Application No: LU/154/22/TEL
Site Address: Land at junction of Hollyhock Way and Worthing Road Littlehampton BN17 6SH
Description of works: Prior Notification under Schedule 2 Part 16 Class A for a proposed 5G telecoms installation: H3G Phase 8 high street pole c/w wrap-around cabinet: and 3 further additional equipment cabinets.

Thank you for your internet representation made on 21st July 2022 which has been recorded as an objection with the comments as follows:

002 SITE LOCATION PLAN

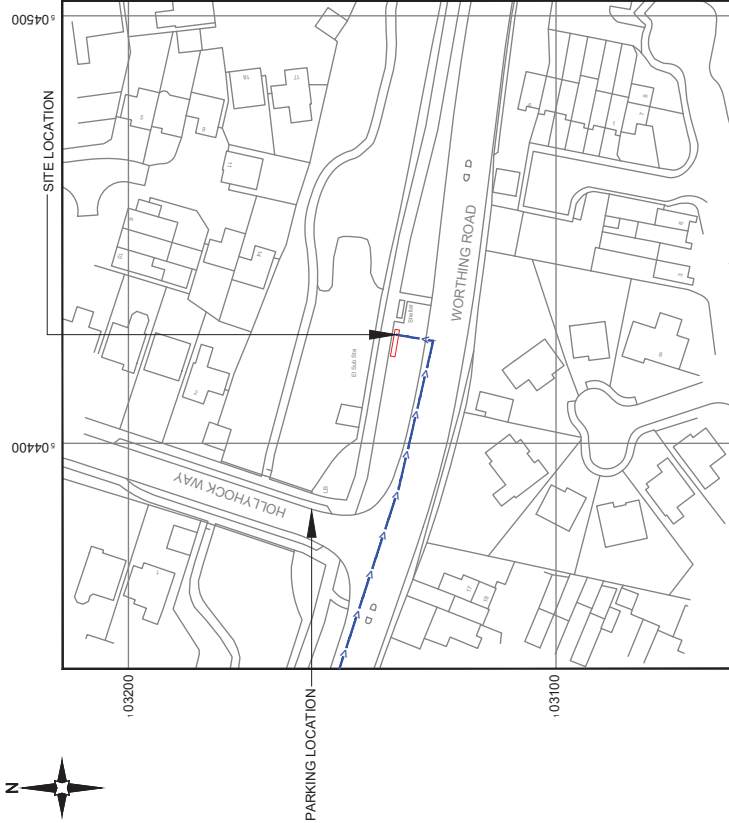
Summerlea School is a short distance away with its entrance in Windsor Drive, however its playing fields extend towards the mast alongside Worthing Road, but the applicant has not consulted the school as its entrance is more than the minimum 200m away from the mast.

No other locations appear to have been considered for this mast such as the Rustington Industrial Estate or perhaps the middle of the Bodyskop Roundabout away from residential properties.

Title: **265 PROPOSED SITE ELEVATION**

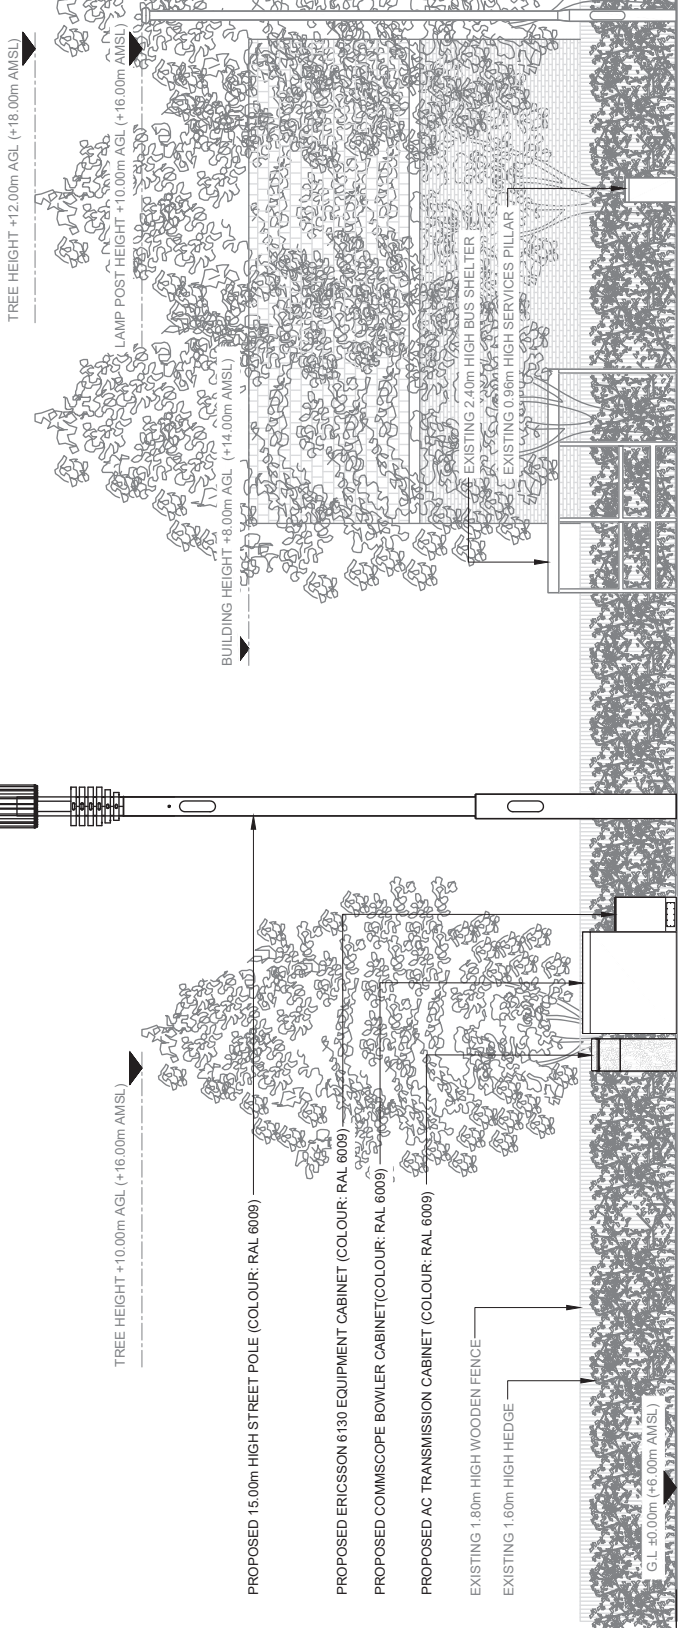
I strongly object to the siting of this mast in the proposed location. The height of the mast is totally out of proportion to the surrounding residential dwellings and will have a High Visual Impact. I understand that government guidelines indicate that masts should cause minimal visual impact.

Houses in all roads on the Beaumont Park Estate immediately to the South of Worthing Road will be affected by this development, as most of the houses have views of this area or will see the mast from their gardens due to its excessive height in relation to its surroundings.
